3/17/26

I-5719B_U5800_Submittal S-008-4B Plans
MI-Engineering- Hydraulics Review

LOCATION: _____
 COUNTY: _____
 DESIGNED BY: _____
 CHECKED BY: _____
 DATE: _____

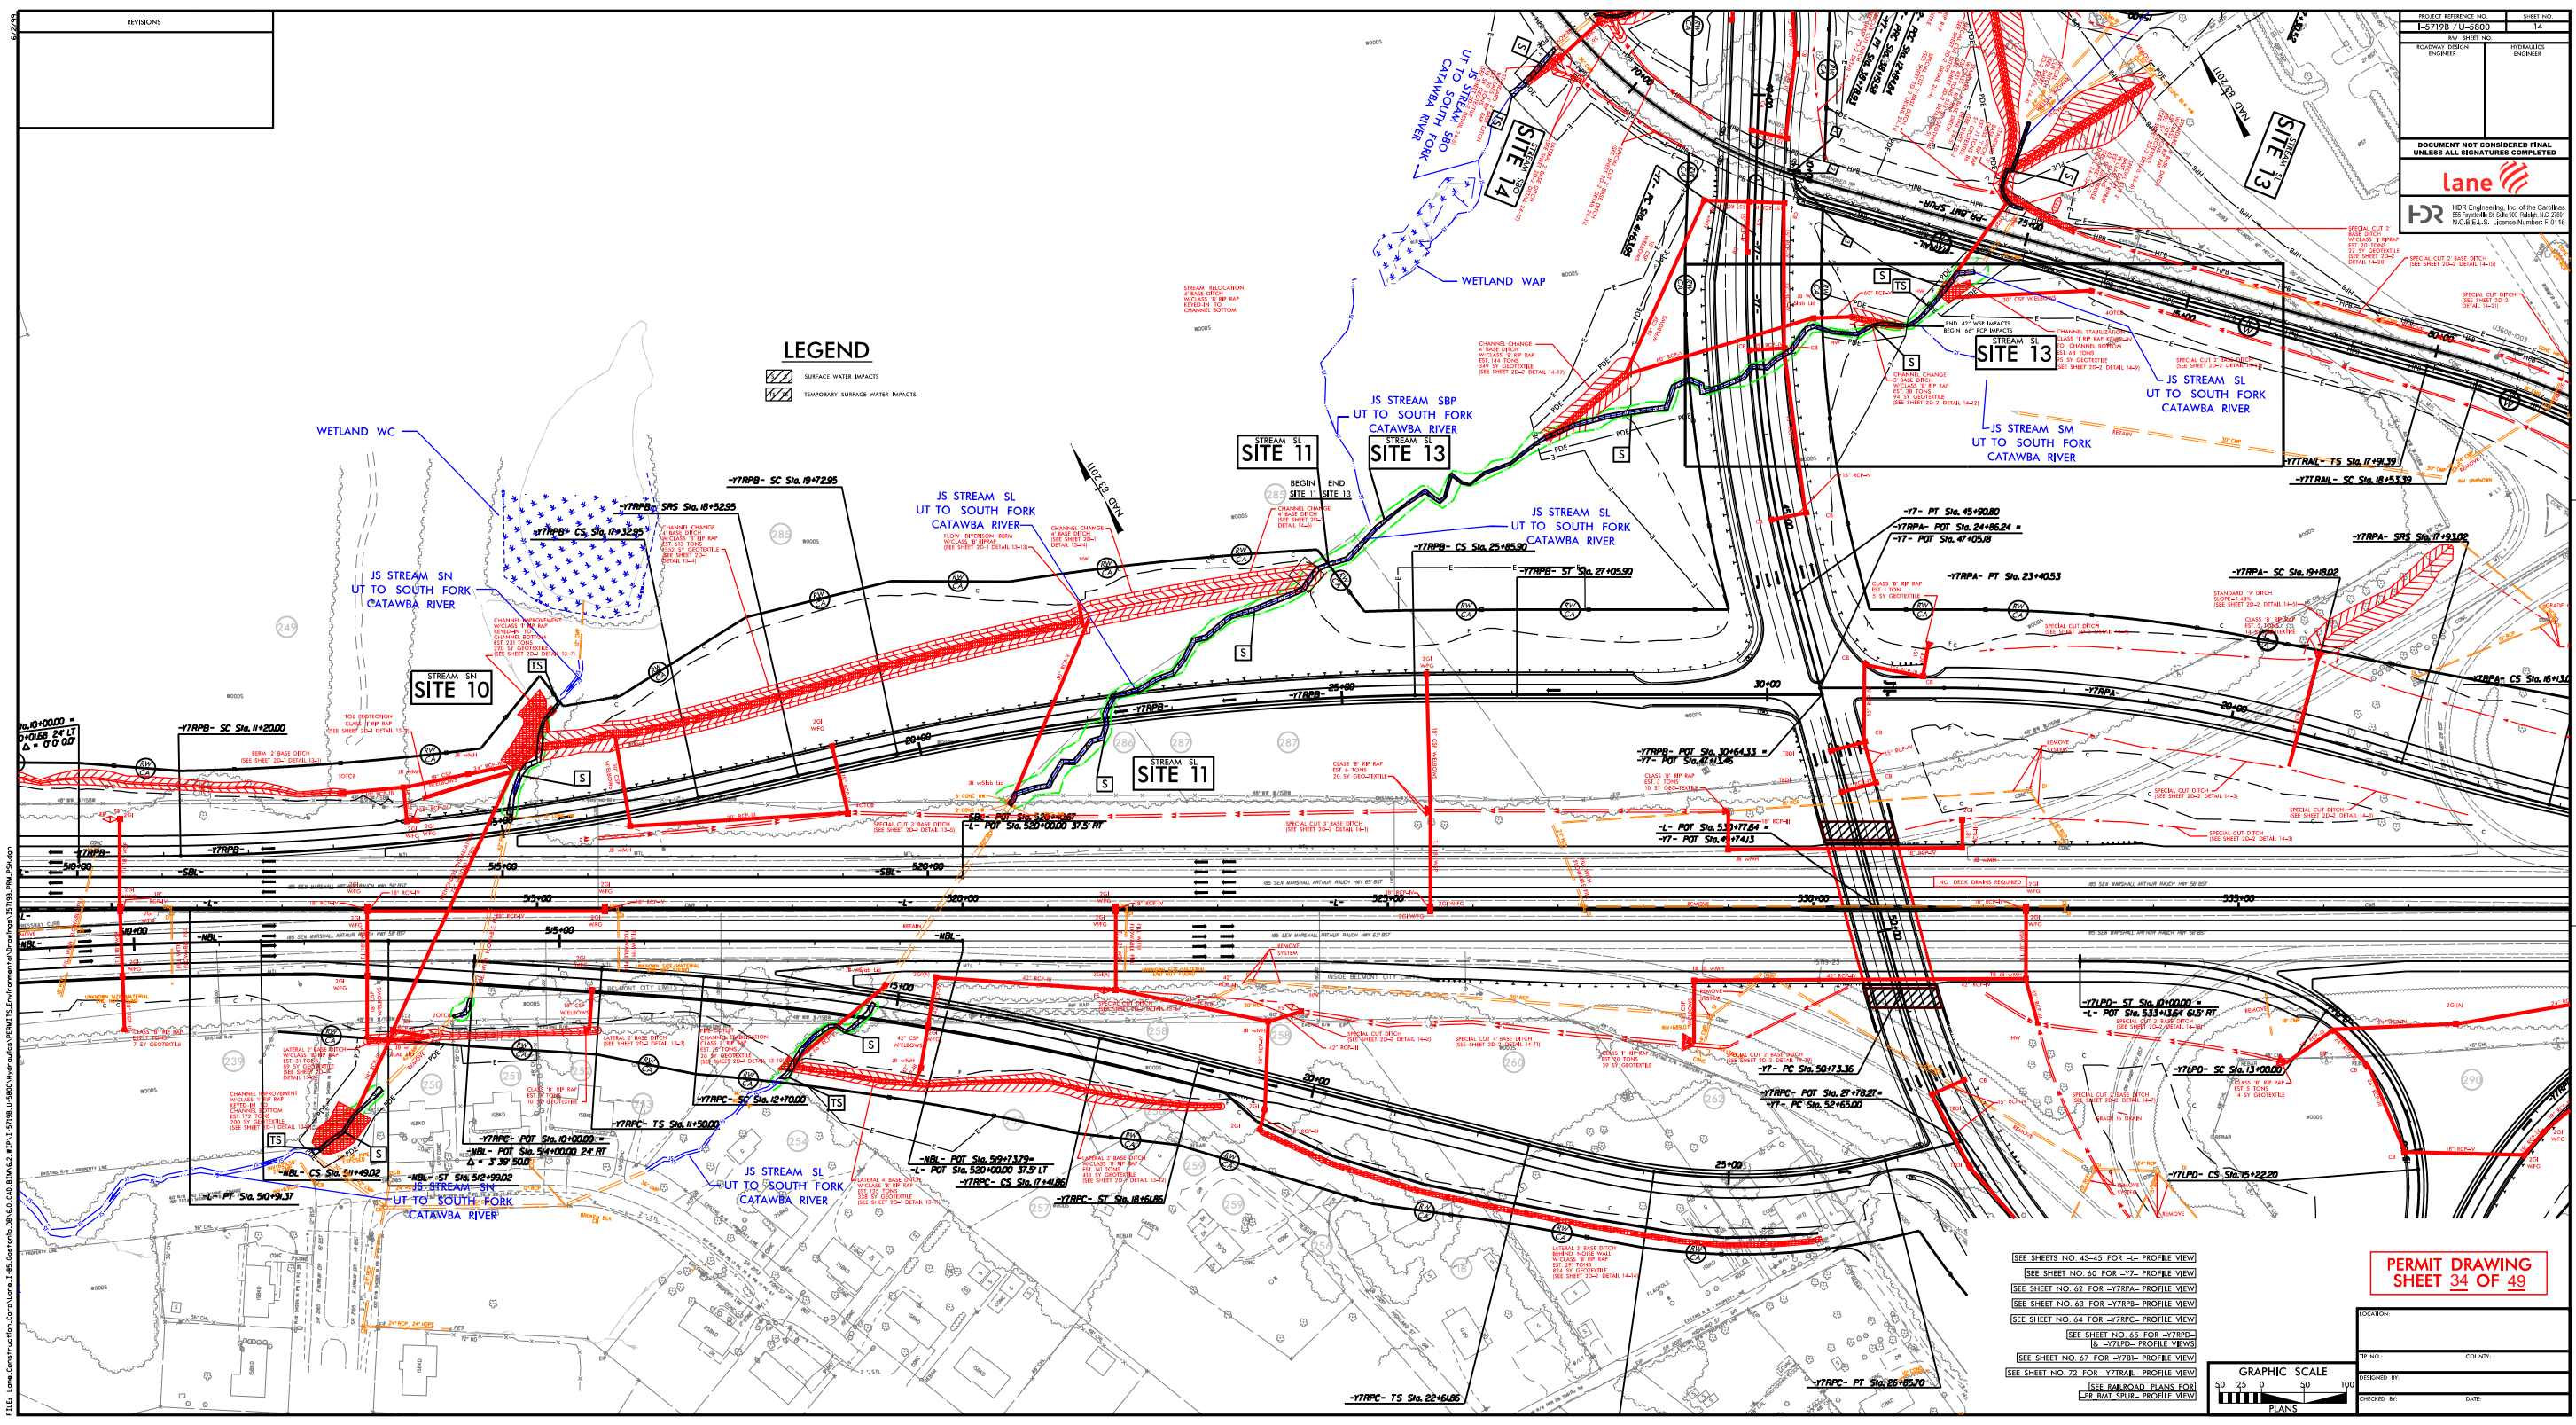
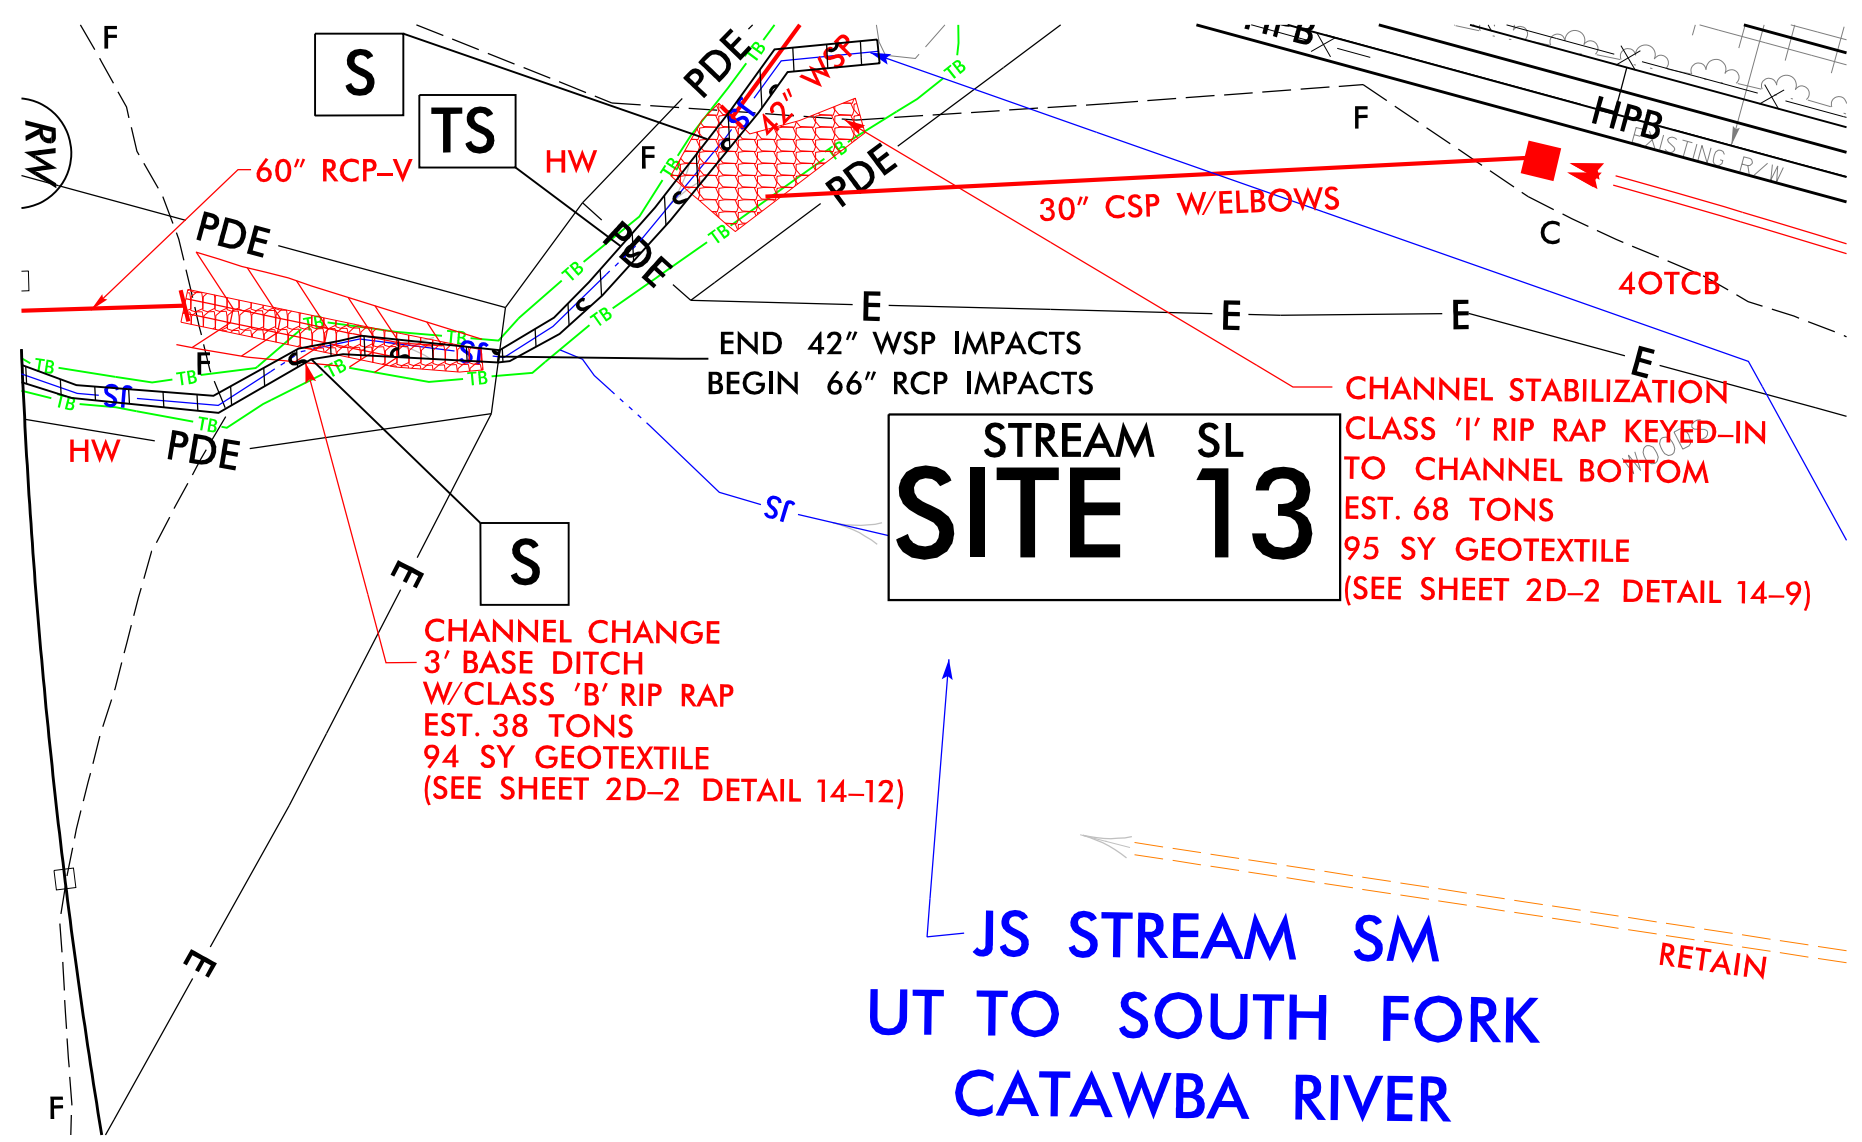
- 66" pipe at station 42+83 -Y7-. The proposed alignment is not the best way to match the existing channel alignment. Be prepared to defend. Does it result in more channel impacts compared to if a straight alignment was used? Does slope match existing channel slope ect..
 - The offset alignment was requested by the contractor to improve construction sequencing/duration.
- 42" pipe at station 13+59 -Y7TRAIL. Is rip rap needed in outlet channel. The slope of pipe is steep and outlet velocities high. May be good to show it embedded in stream bed.
 - Riprap was revised to show key-in to channel bottom.

PROJECT REFERENCE NO. L-5719B / U-5800	SHEET NO. 15
RW SHEET NO.	
ROADWAY DESIGN ENGINEER	HYDRAULICS ENGINEER
DOCUMENT NOT CONSIDERED FINAL UNLESS ALL SIGNATURES COMPLETED	
HDR Engineering, Inc. of the Carolinas 555 Fayetteville St., Suite 900 Raleigh, N.C. 27601 N.C.B.E.L.S. License Number: F-0116

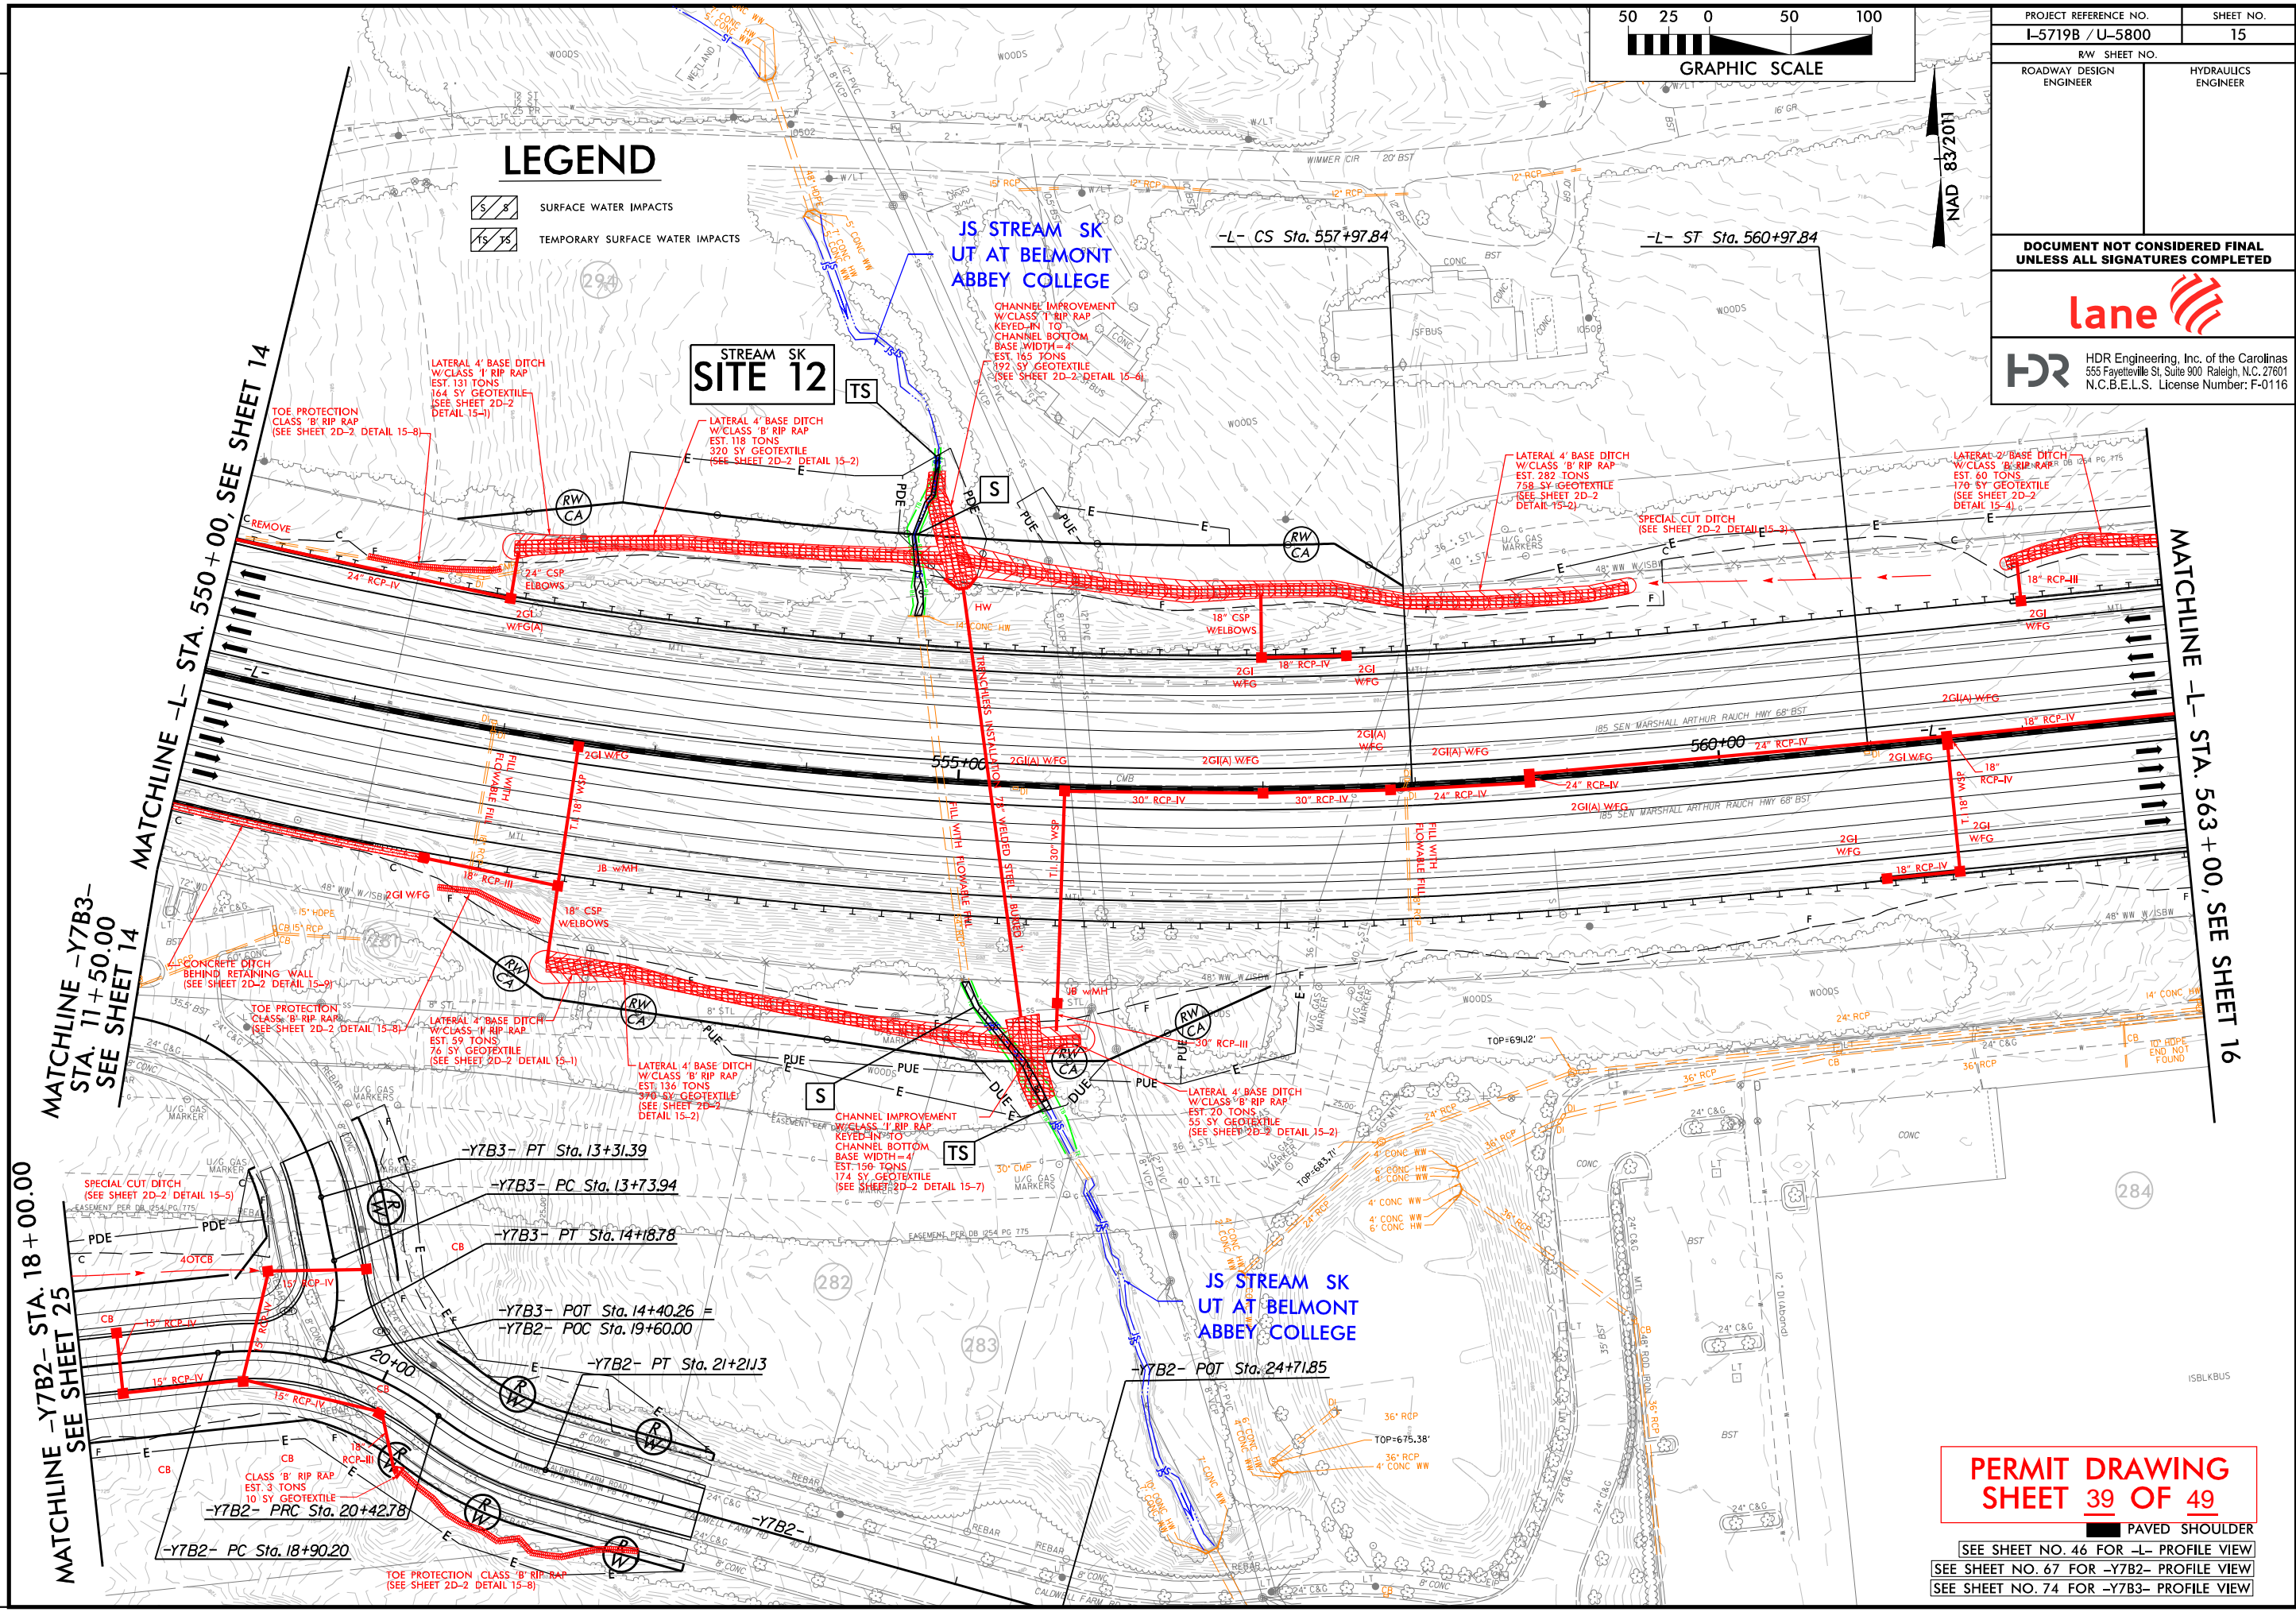
- 78" pipe at station 555+20 -L-. Are sills proposed for this pipe? It is hard to tell from CSR as they are not specifically mentioned but appear to be shown in inlet and outlet details.
 - Discussion for meeting.
